In addition to responding to DPIE's RFI's in the letter of 08.06.21, this RTS includes a request for a plan swap to provide updated office elevations for warehouses 2A, 2C & 2D.

### 1. RFI response to DPIE's letter of 08.06.21

ELEVATION NORTH - OFFICE B

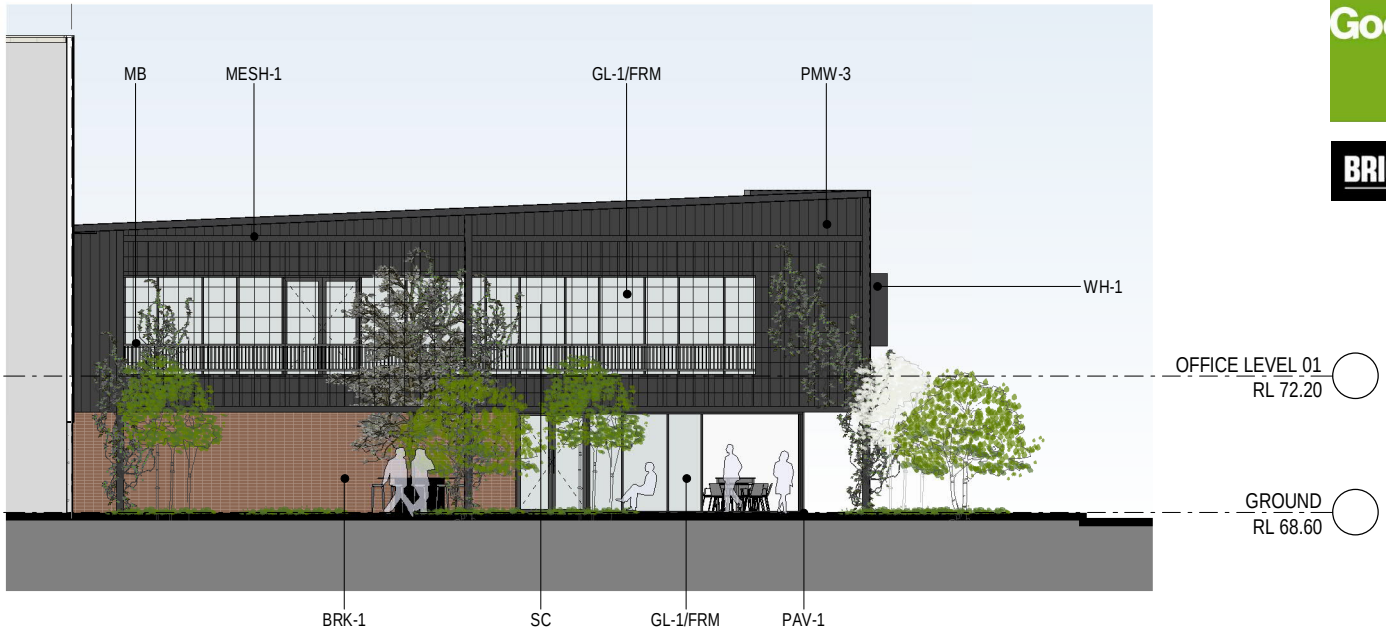
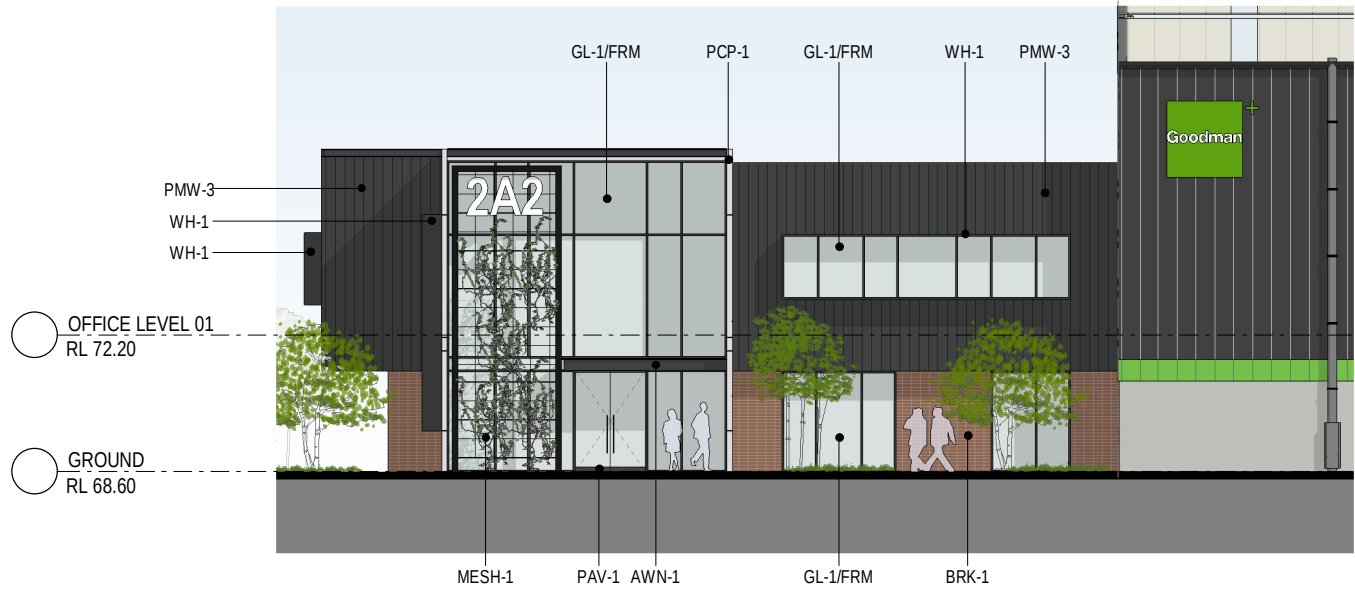
The facades of warehouse 2A, 2C & 2D are proposed to be updated from that submitted with the SSD application. The reason for the minor proposed updates are to bring the office elevations in line with the revised office designs and elevations for the estate and that of which is being sought as part of the local council, Building 3B development at the Estate. This will provide for a consistent design intent across the estate at all buildings where the office is yet to be completed will be updated to reflect a similar design intent.

- Change from blockwork to brickwork;
- Balcony provided to level 1 office areas;
- Extended awning providing significant shade over outdoor areas;
- Enhanced landscaping features including feature planting in outdoor areas and vines enclosing the outdoor areas
- Enclosed hood of office entry

1 ELEVATION WEST - WAREHOUSE 2C 1 : 250

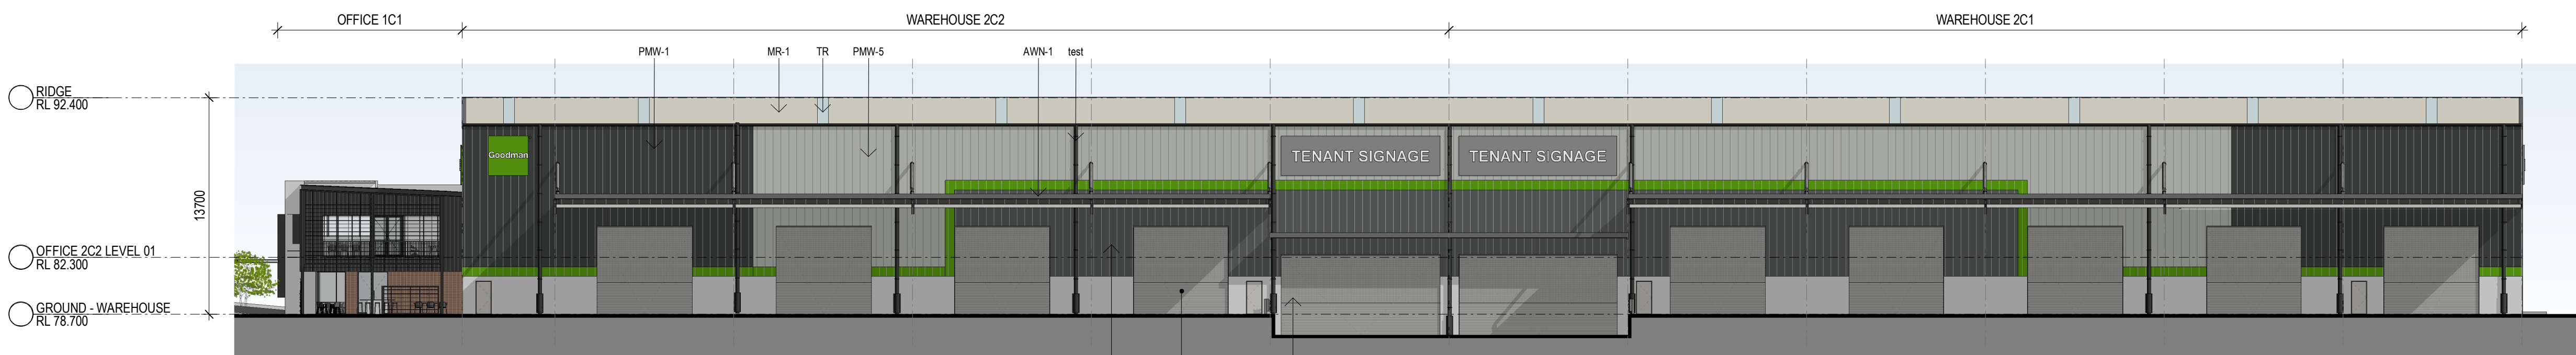
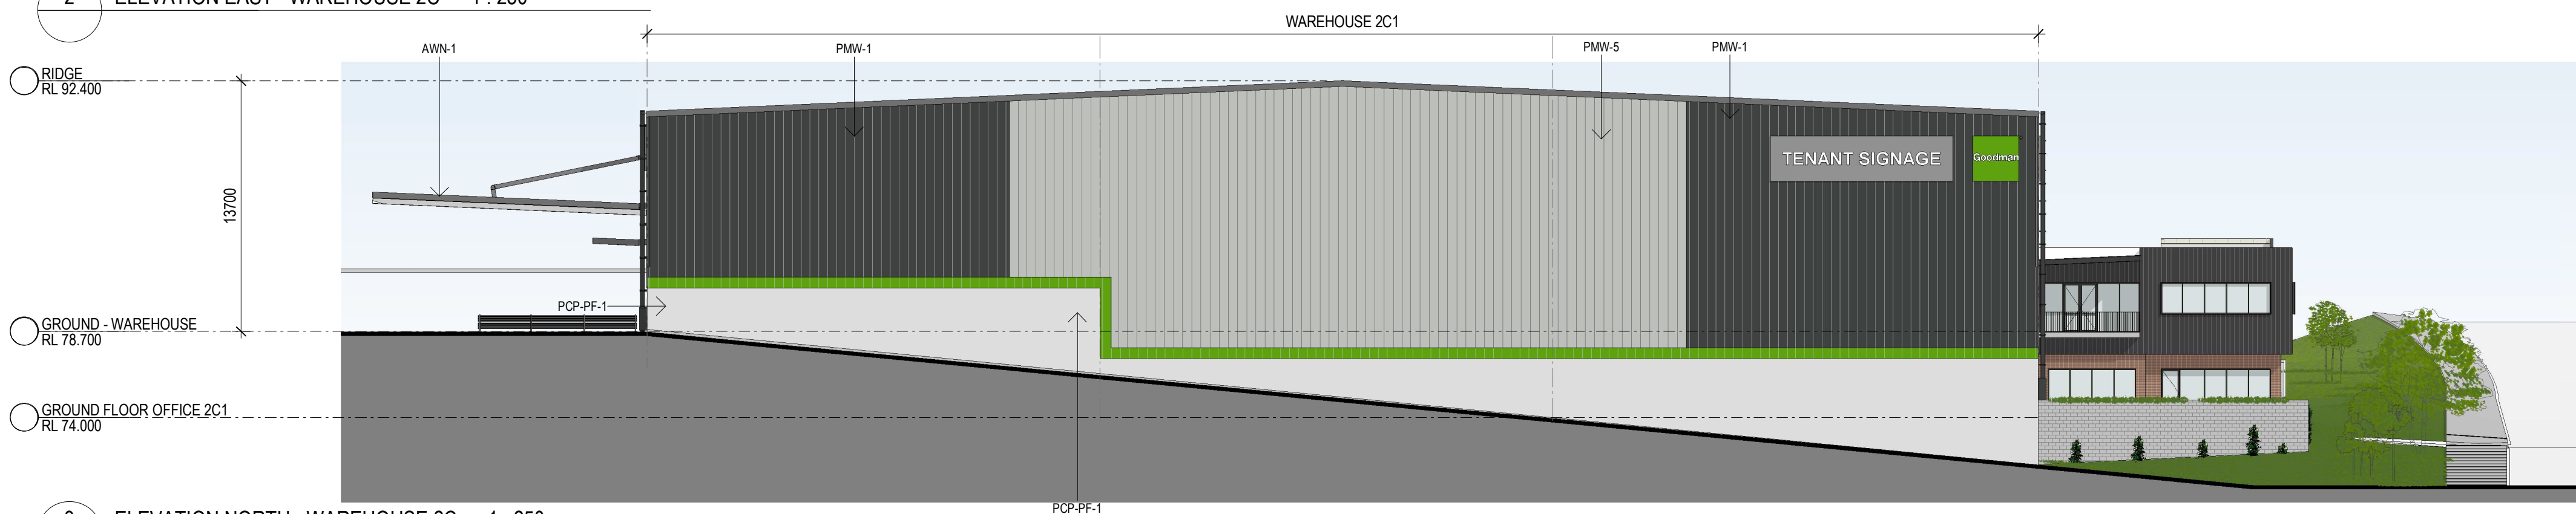
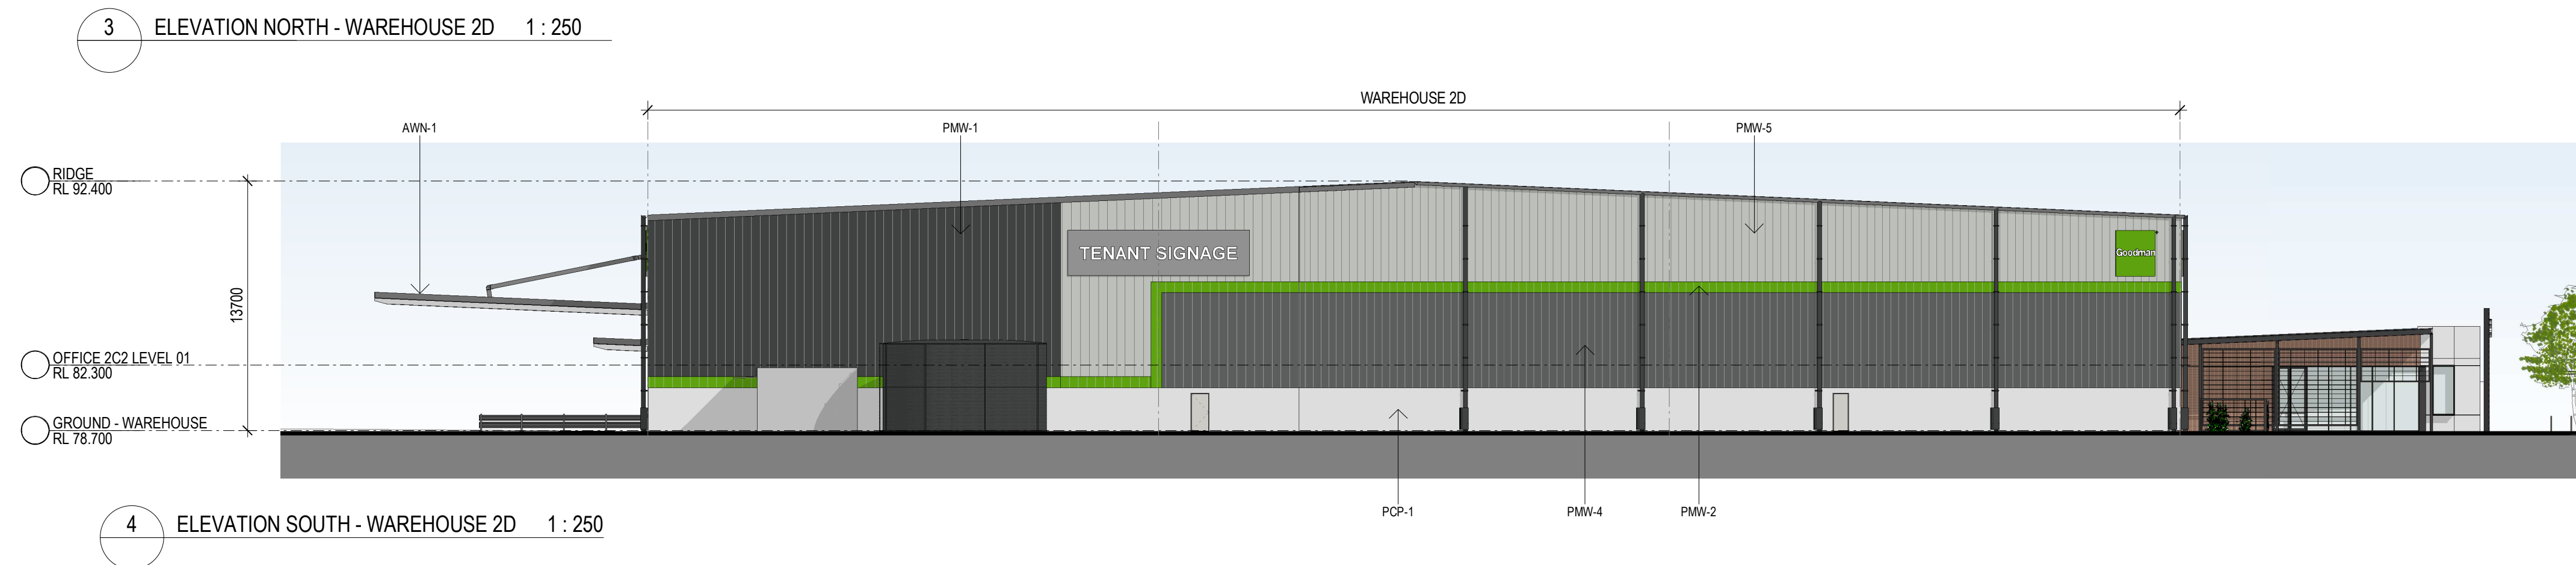
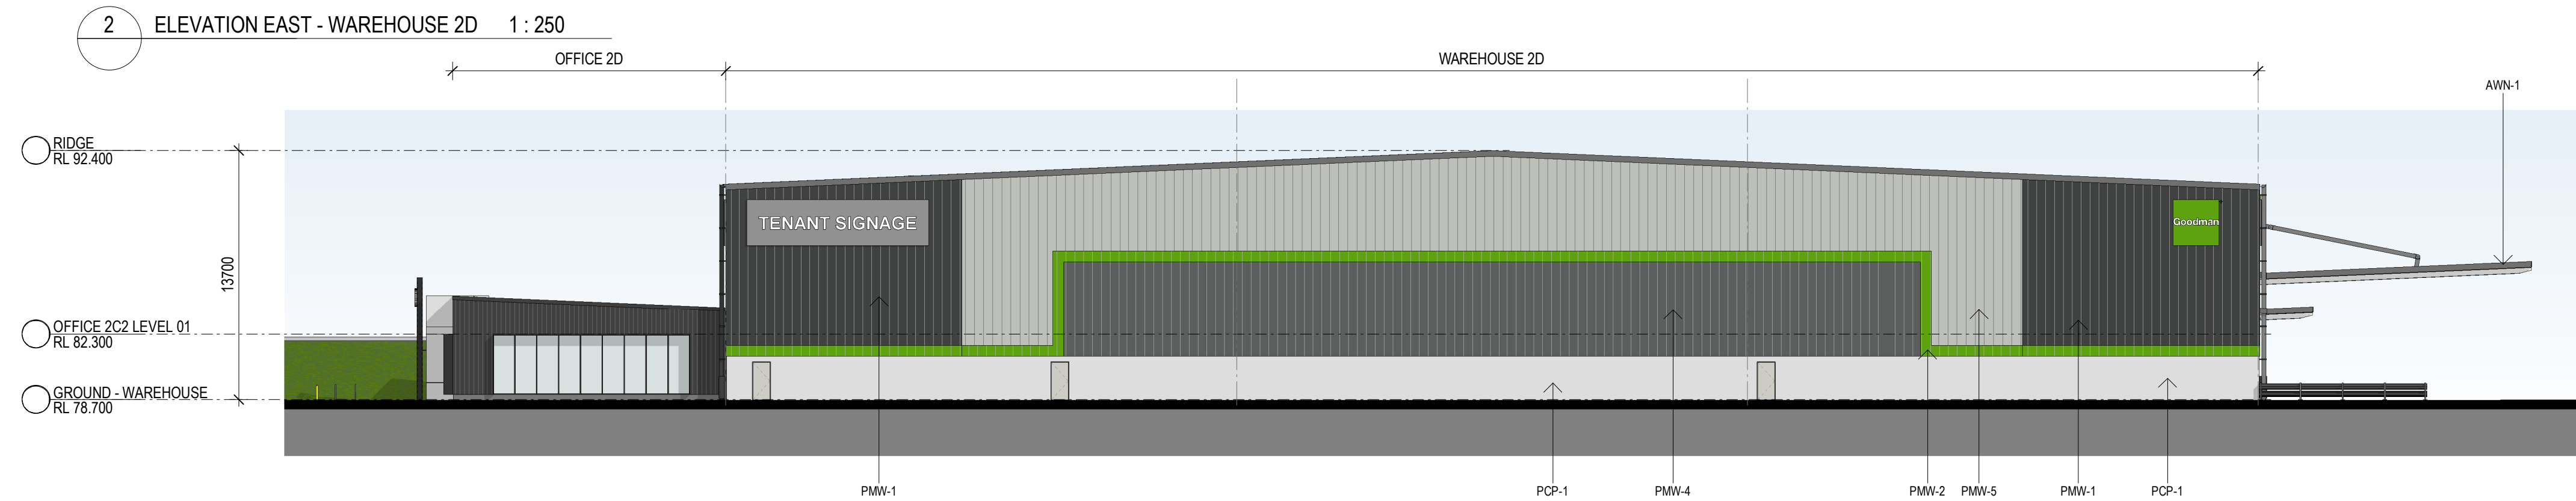
The Department notes that the effective height of Building 2C is approximately 22.2 m, which exceeds the 15 m limit in the Oakdale West Estate Development Control Plan (OWEDCP). Please provide justification for the non-compliance or amend the building design to achieve compliance with the OWE DCP.

- It is confirmed that the warehouse ridge height of Building 2C is 13.7m. This measurement is taken from the The building height is appropriate calculated from the approved pad level, considered the 'natural ground level'. From this calculation the warehouse has an effective height of 13.7m and is therefore below the 15m height limit and compliant with the height control and consistent with how the heights of other warehouses at Oakdale West have been measured.

- It's acknowledged that while warehouse 2C presents as 13.7m from the eastern and southern elevations, from the northern and western elevations there are portions of the façade that present as up to 22m in height. This is primarily due to the sloping nature of the land for Lot 2C between 0 and 8m from east to west.

- It is noted that the proposed design prefers a gentle slope / batter from warehouse 2C to Estate Road 03 rather than an aggressive retaining wall right on the boundary of Estate Road 03. The base of the warehouse 2C below the 13.7m on the northern and western elevations are considered 'retaining walls'. This accounts for the portion of the building that is perceived to be over 13.7m of height, and accounts for the increased perception of building height, bulk and scale.

- The architecture plans have been updated to articulate the northern and western elevations to reduce the appearance of bulk and scale. The amended design minimises the bulk and scale of the building by carrying the building façade treatment to a lower level to provide an appearance of a reduced height retaining wall.
- A photomontage (See **Appendix B**) has been prepared which demonstrates that the proposed landscaping will provide good visual buffering and will reduce the appearance of bulk and scale from the internal Estate Road 03.
- It is noted that compared to the approved Lot 1A and Lot 2B warehouses, with heights of 36m and 26m respectively (excluding solar), the height range of Warehouse 2C between 13.7m - 22m will appear recessive by comparison.
